City of Albuquerque Stormwater Construction Site Inspection Report

| ESC File No. | A11E0111 | Project Name: | McMahon Lots | | |
| NPDES Id. No. | NMR1002NB | Location: | 5710 McMahon Blvd | | |

TEMPORARY EROSION AND SEDIMENT CONTROL PLAN

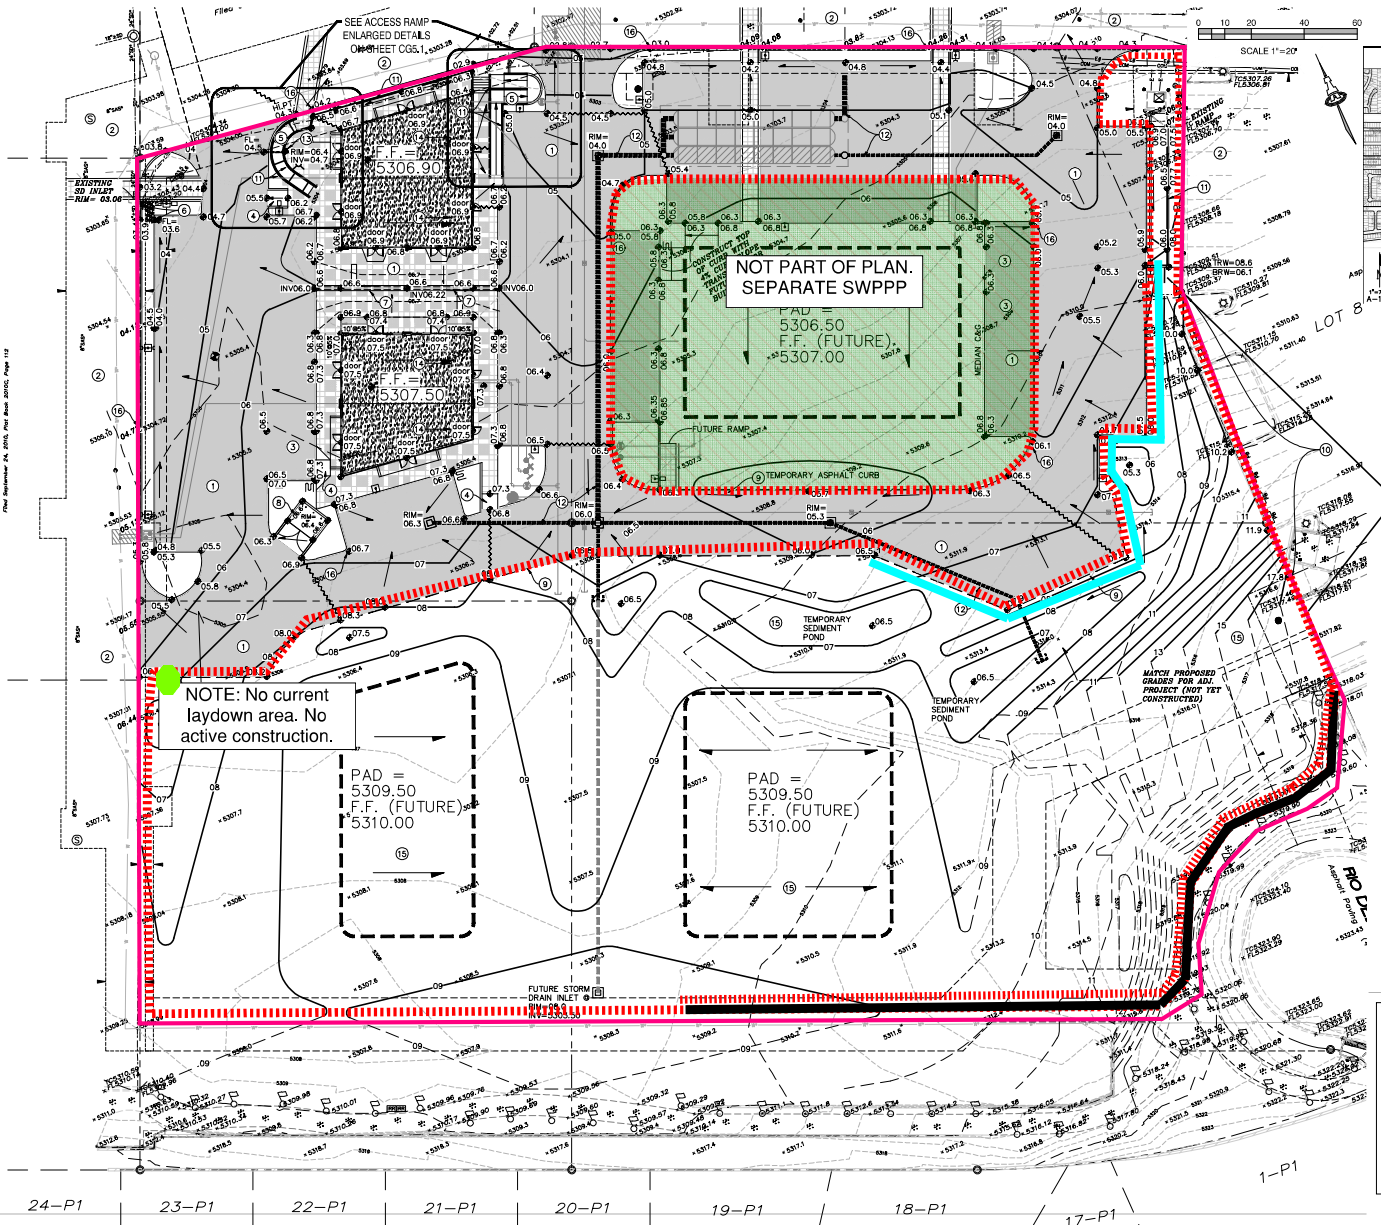
| ESC File No. | A11E0111 | Project Name: | McMahon Lots | | |
|---|---|--|-------------------------|---------------|-----------|
| 3 | Silt fence most OK. Additional fence should be added around center dirt island & BMP controls should be updated on SWPPP map. | | | | |
